Ár dTag|Our Ref. TII23-122375

Do dTag|Your Ref. NA06S.316119

Re: DART+ South West Electrified Railway Order 2022

Transport Infrastructure Ireland (TII) acknowledges receipt of referral of the DART+ South West Railway Order application (Hazelhatch & Celbridge Station to Heuston Station, and Heuston Station to Glasnevin) by Córas Iompair Éireann.

**WORKS LAYOUT PLAN
M50 AND PARK WEST
SCALE 1:1250 (@A0)**

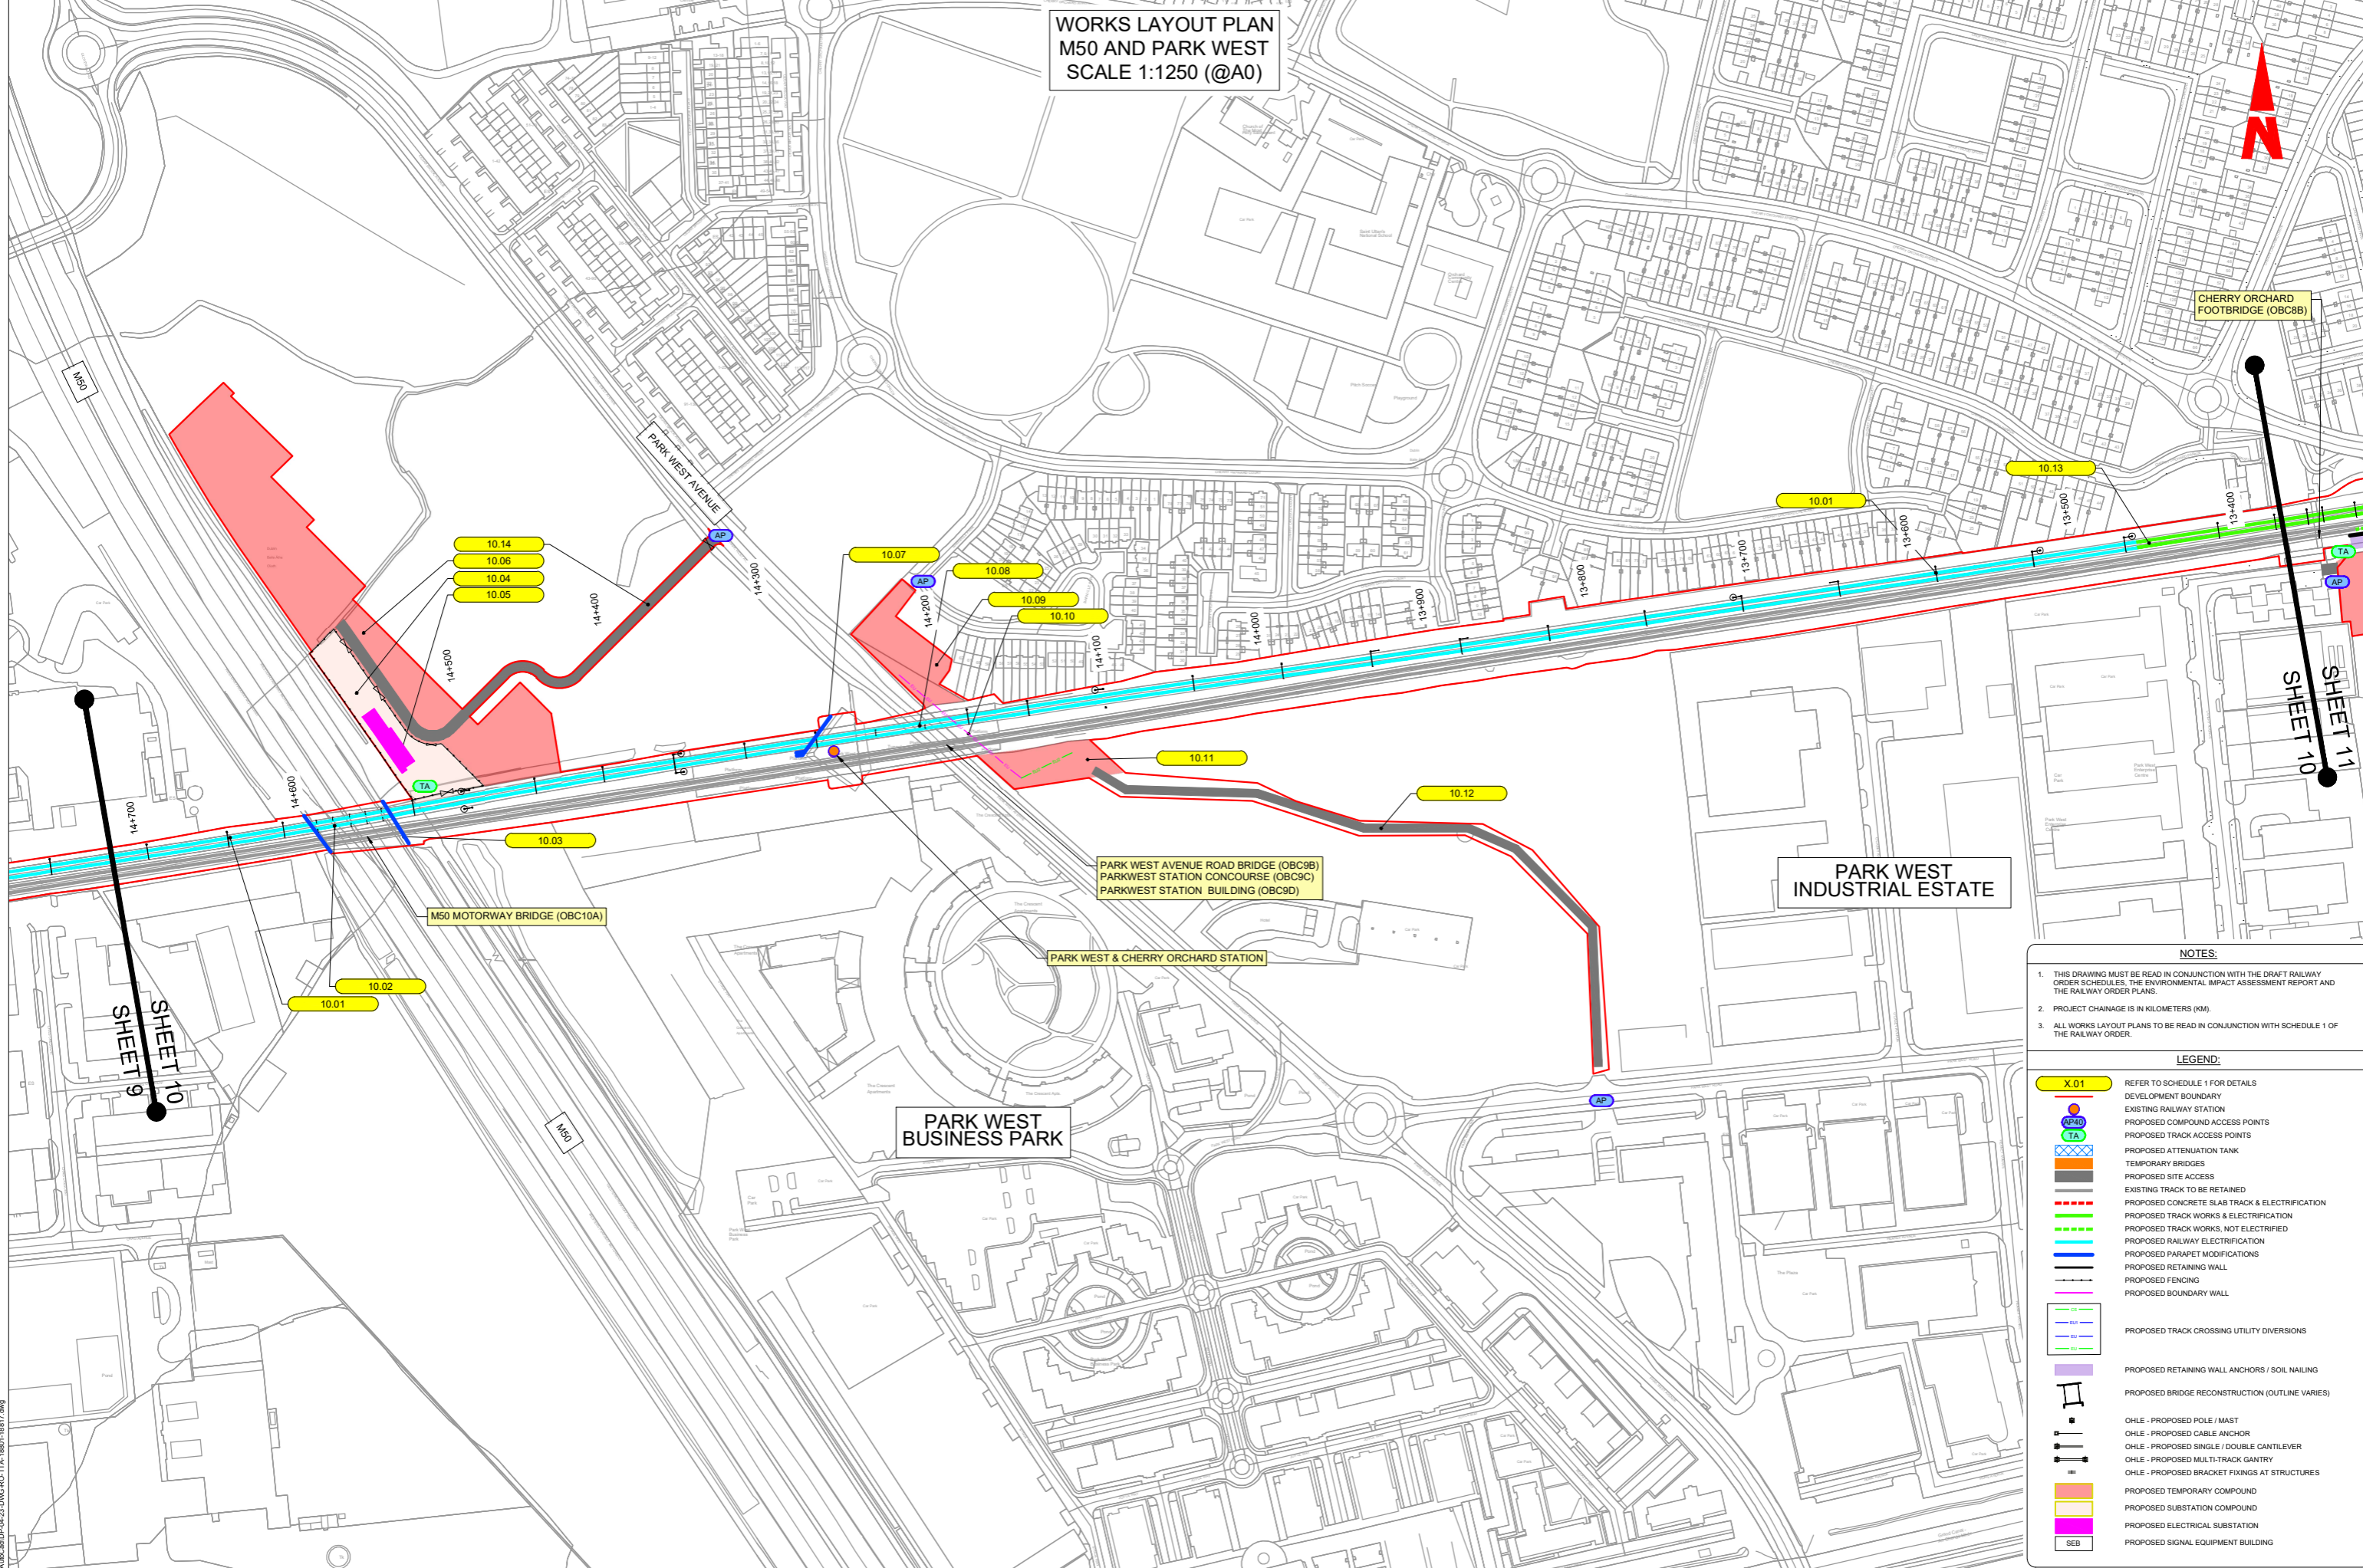
Book 1 of the Railway Order Drawings contains *Works Layout Plan No. WP01* indicates proposed works along the railway line that crosses the M50 the most heavily trafficked national primary national route.

The Railway Scheme crossing of the M50 between junctions 7 (N4) and 9 (N7) is indicated on submitted drawings under *M50 Motorway Bridge ref. OBC10A*. TII records this bridge, part of the M50, as *Ronanstown Railway Bridge (TII Structure ID IC-M50-010.00)*.

TII notes that it is proposed to install a temporary construction compound along the eastern side of the M50 immediately north of *Ronanstown Railway Bridge*. Part of this compound will be permanent utilised to install a proposed substation with welfare facilities.

Project Title DART + SOUTH WEST
Drawing Title CONSTRUCTION COMPOUNDS LOCATION OVERVIEW
Drawing File Name DP-04-23-DWG-RO-TTA-18848
Version v01
Status S3

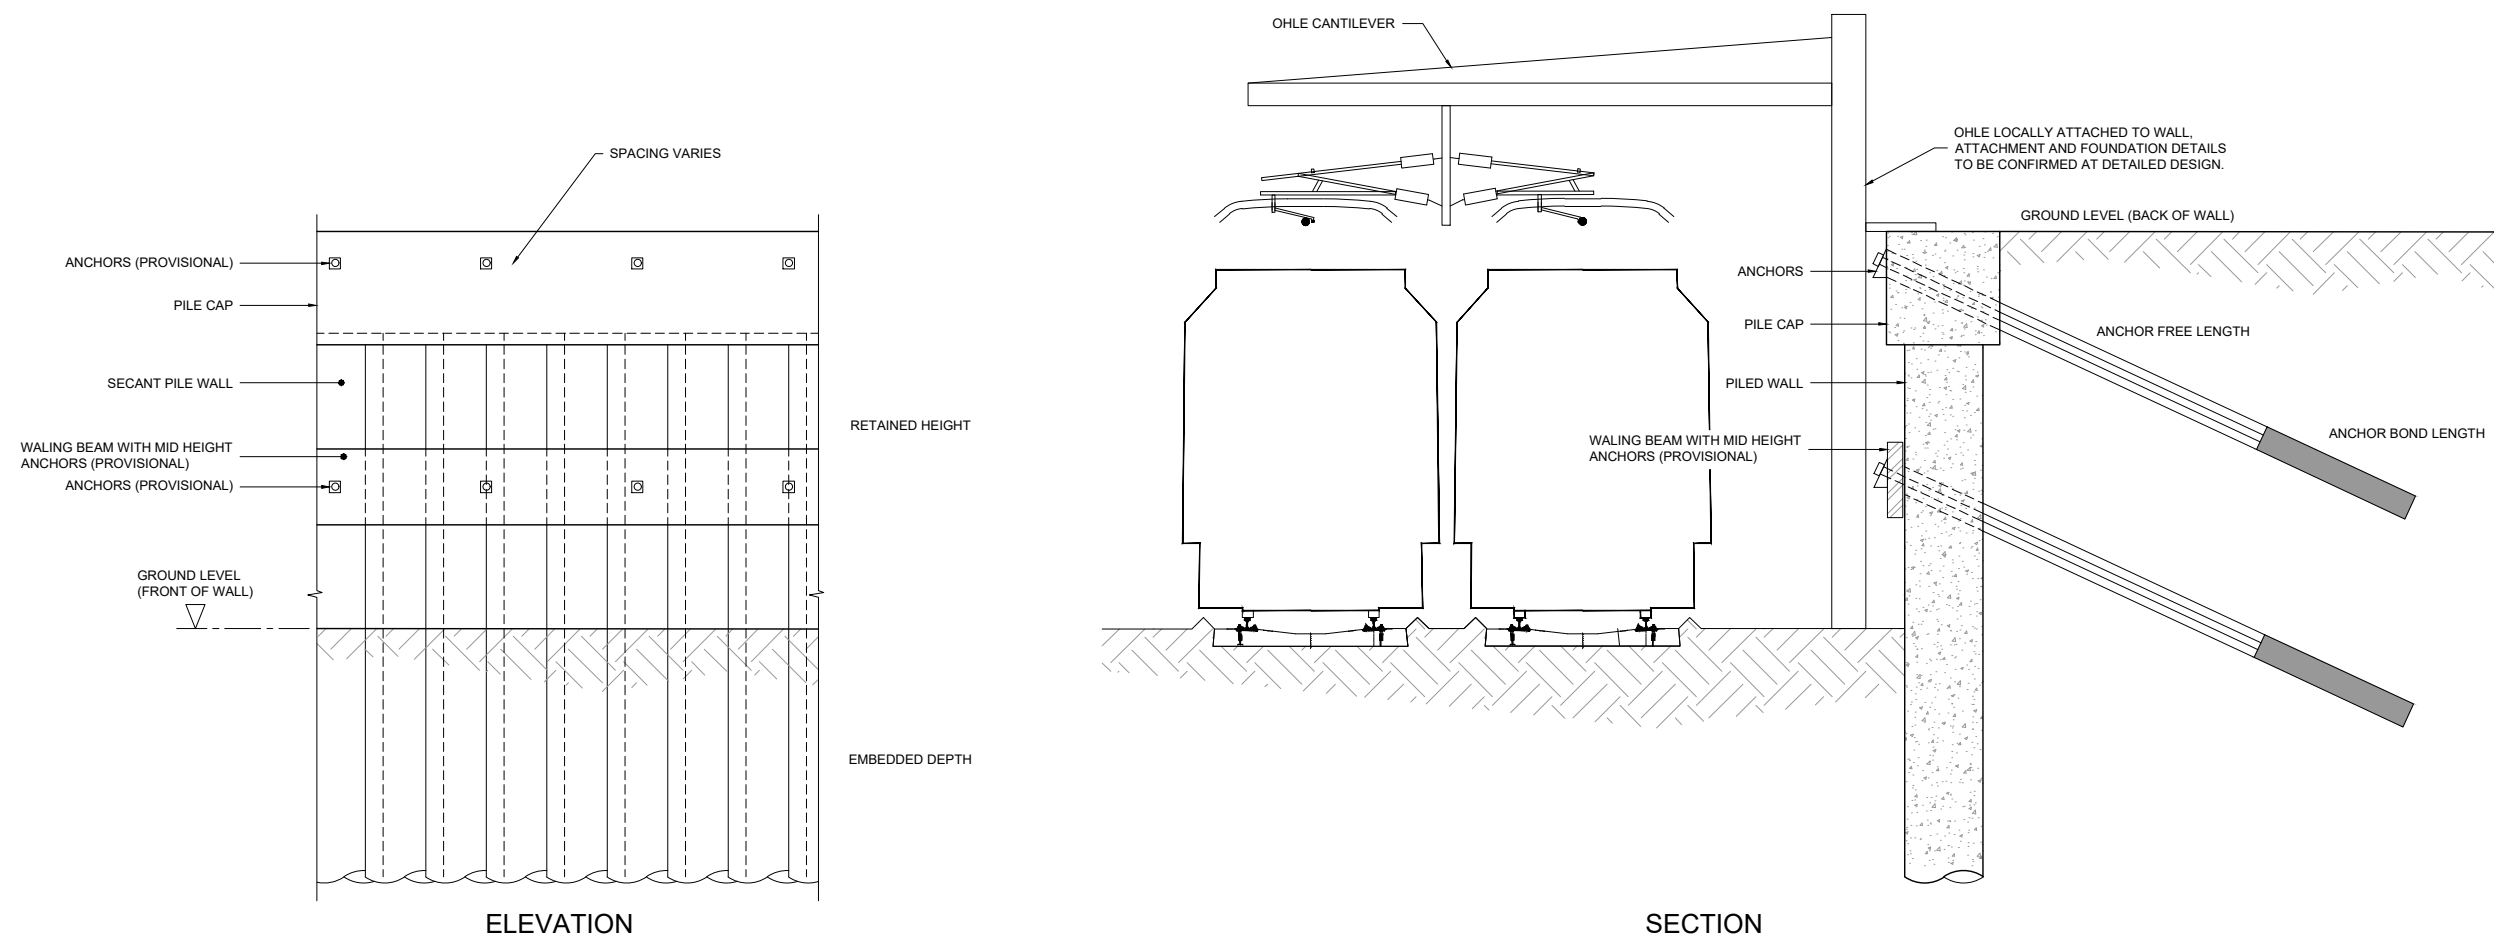
| Proposed Railway Order Drawings, Book 3 - General Arrangement Drawings | | | |
|---|-------------------------|--|--|
| DP-04-23-DWG-RO-TTA-18848 | VER01 | Construction Compounds Location Overview | Indicates Existing, Main and Satellite Compounds proposed for use during construction and operation phases of the scheme. <ul style="list-style-type: none">Indicates a Main Compound ID CC-SUB-3A-21363-A, ref. Park West (Substation)Indicates a Main Compound ID CC-SET-3A-21363-A, ref. Park West |
